Your Ref: SSD-6693-Mod-1  
APA Ref: 443985

**RE: Submission on the Rye Park Modification Wind Farm**

The Rye Park Modification Wind Farm Updated Development Layout Plan (dated 07/04/20, Version A) shows the various components of the Wind Farm including but not limited to wind turbine locations, access tracks and associated electrical infrastructure. With proposed wind turbines #83 and #143 located approximately between 700-750 metres away from APA's pipelines at the closest point.

## C.2 DEVELOPMENT LAYOUT

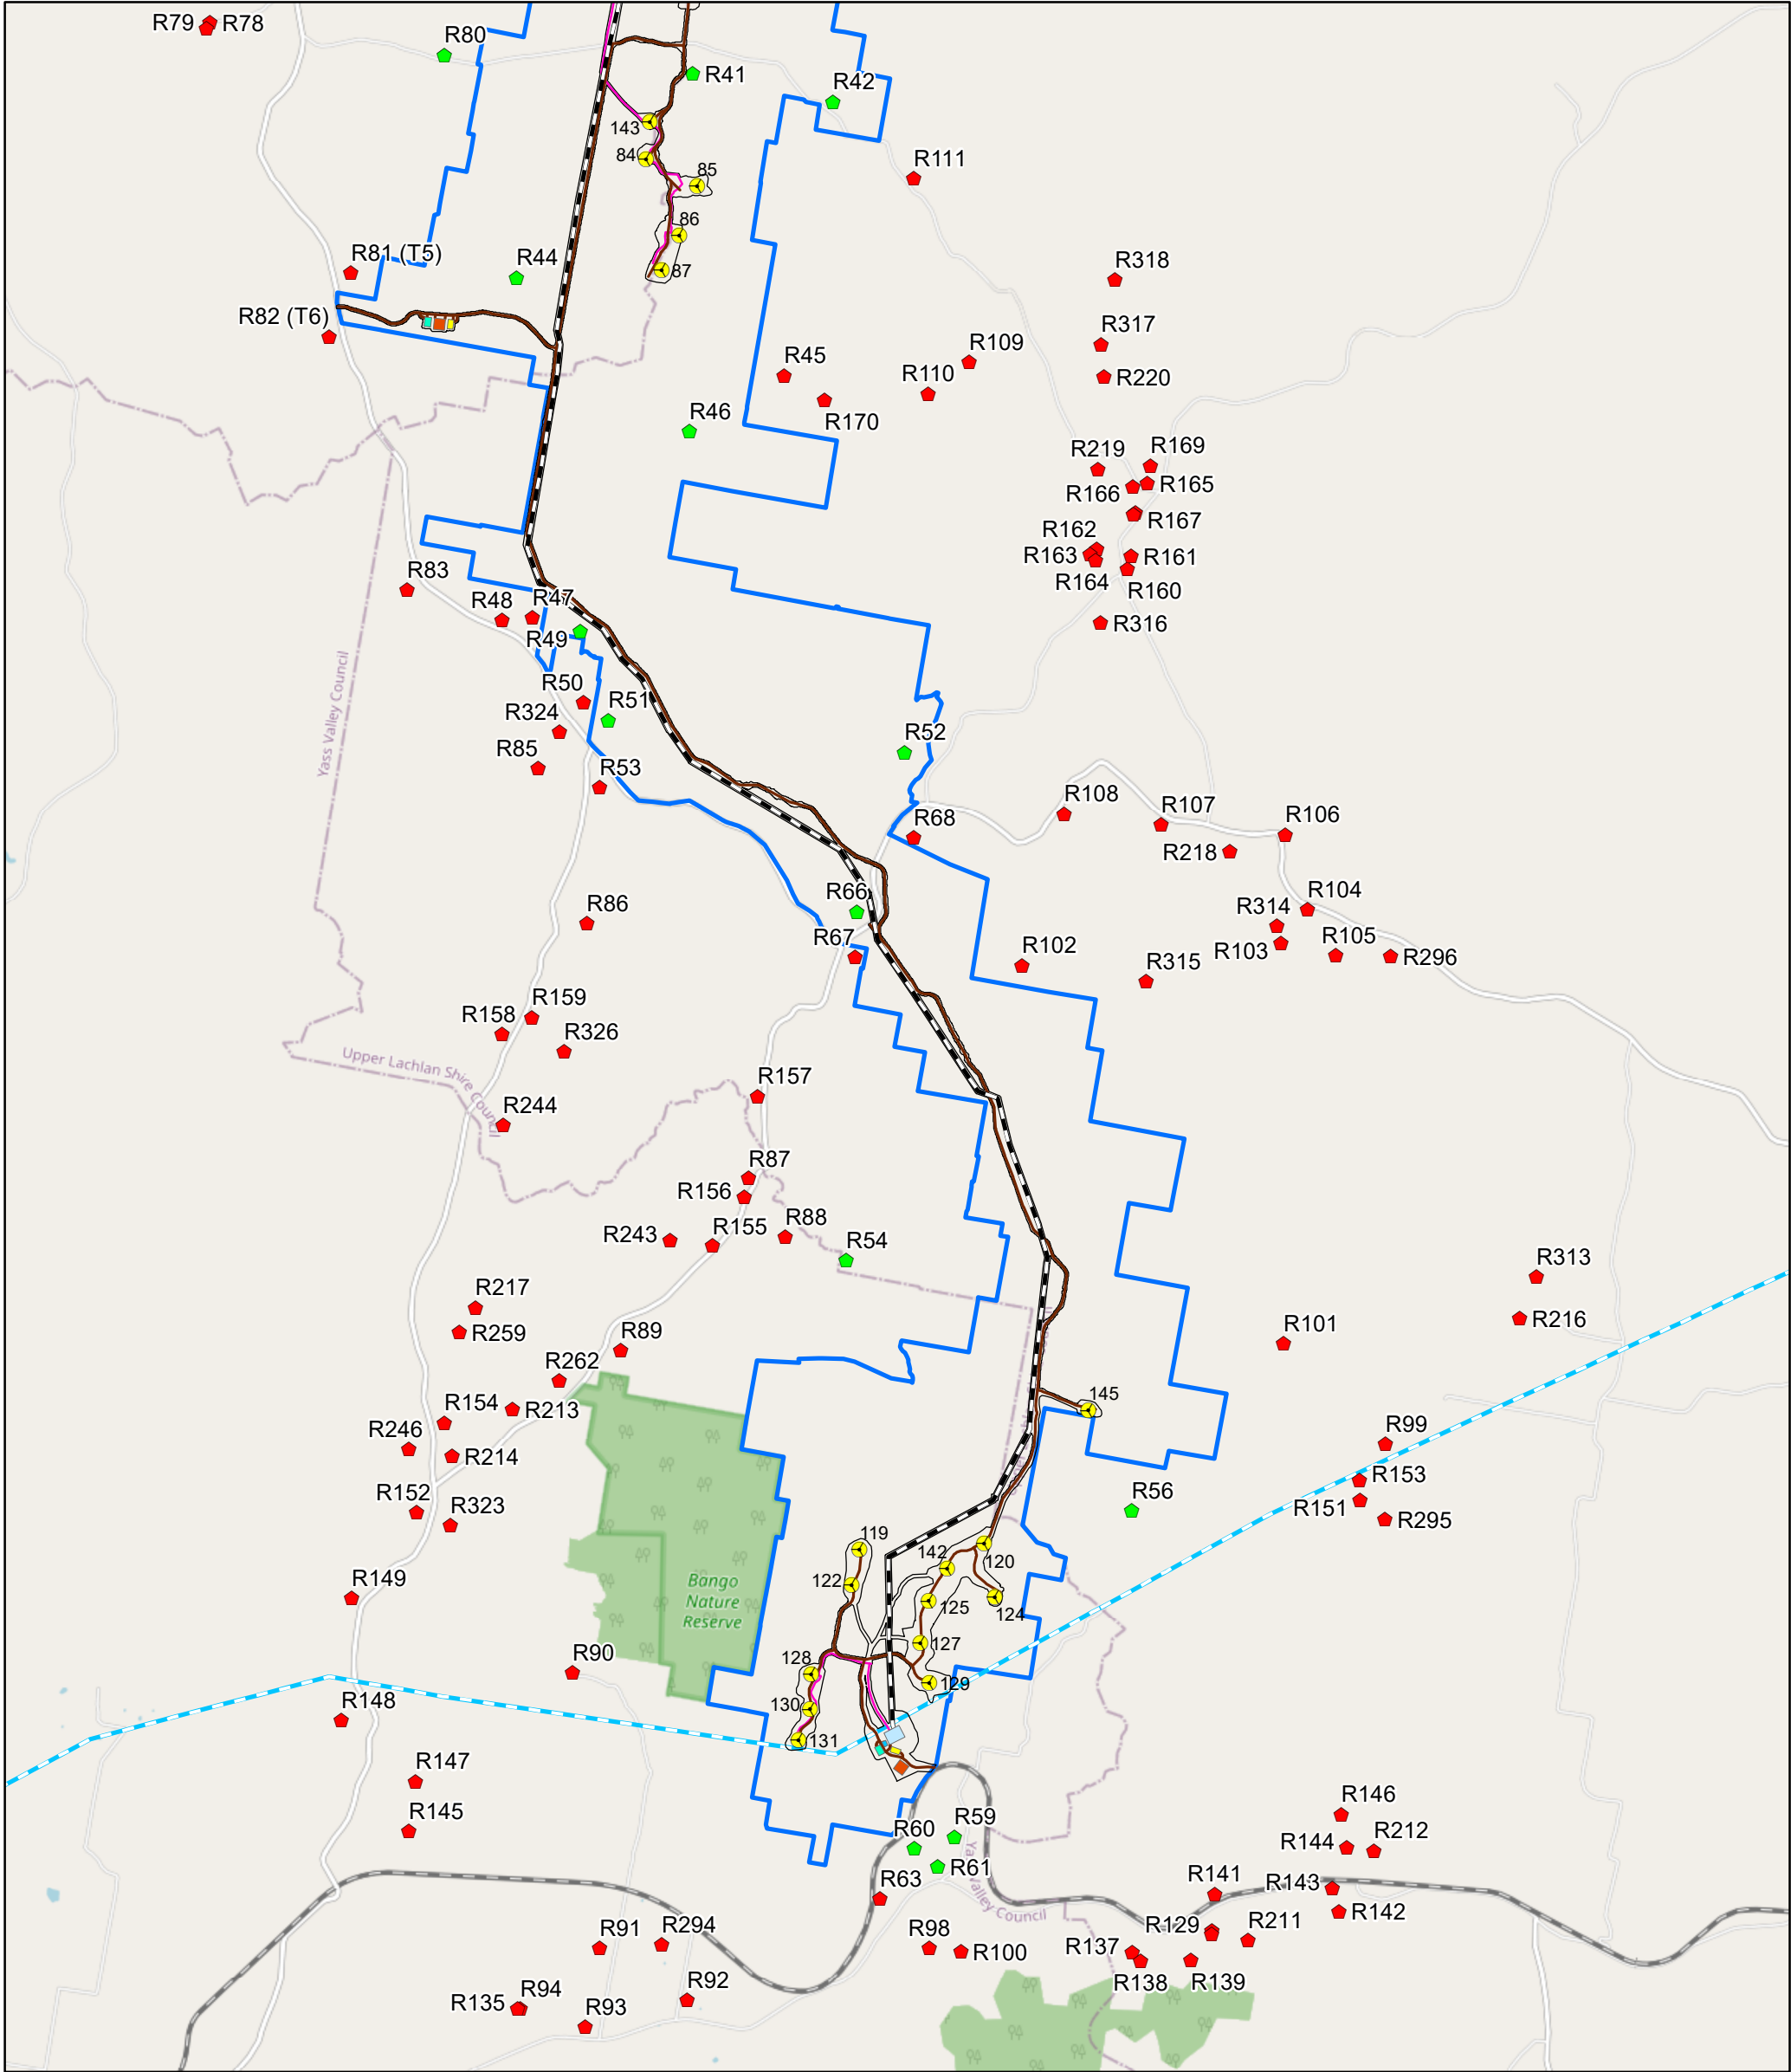
In review of the abovementioned plan against the previous layout, APA welcomes the relocation of proposed Collector Substation, Proposed O&M Building, and Proposed Construction Compound to the southern portion of the Updated Development Layout Plan. In addition, the reduction in the number of proposed electrical crossings of APA's pipelines.

However, the Updated Development Layout Plan does not clearly mark APA's pipeline easement being for high-pressure gas transmission pipelines. Therefore, the level of risk associated with any intrusion into the easement is not adequately communicated to those undertaking site works. The easement should be clearly identified as an easement for high pressure gas transmission pipelines on all relevant plans. In addition, the easement should be hatched and notated as 'no works to occur without the prior authorisation of the pipeline operator'.

The proposed development involves several parallel electrical crossings (33kV and up to 330kV) of APA's pipelines. APA seeks to minimise the number of crossings and have these perpendicular to the pipeline if possible. This should include the co-location of road and services crossings. No work on the easement, including crossings, changes in ground level or other works, may occur without the prior authorisation of APA. Detailed design for crossings will need to be informed by field works to positively locate the pipeline (alignment and depth). Such field works must only be performed under APA permit.

Crossings of underground services must accord with APA requirements, particularly minimum separation distances. Road crossings for heavy vehicles (as expected to be required in this case along Flakney Creek Road or Pudman Creek Road) will require a concrete slab crossing to disperse loads on the pipeline to an acceptable level. This will need to be designed to APA requirements. Vehicular crossings during construction and operation will need to be at the agreed crossing points.

All plans which include the area of the gas pipeline easement must have the easement clearly identified with hatching on the full width of the easement. The easement must also be clearly labelled as *'high pressure gas pipeline easement – no works to occur without the prior authorisation of the pipeline operator'*.
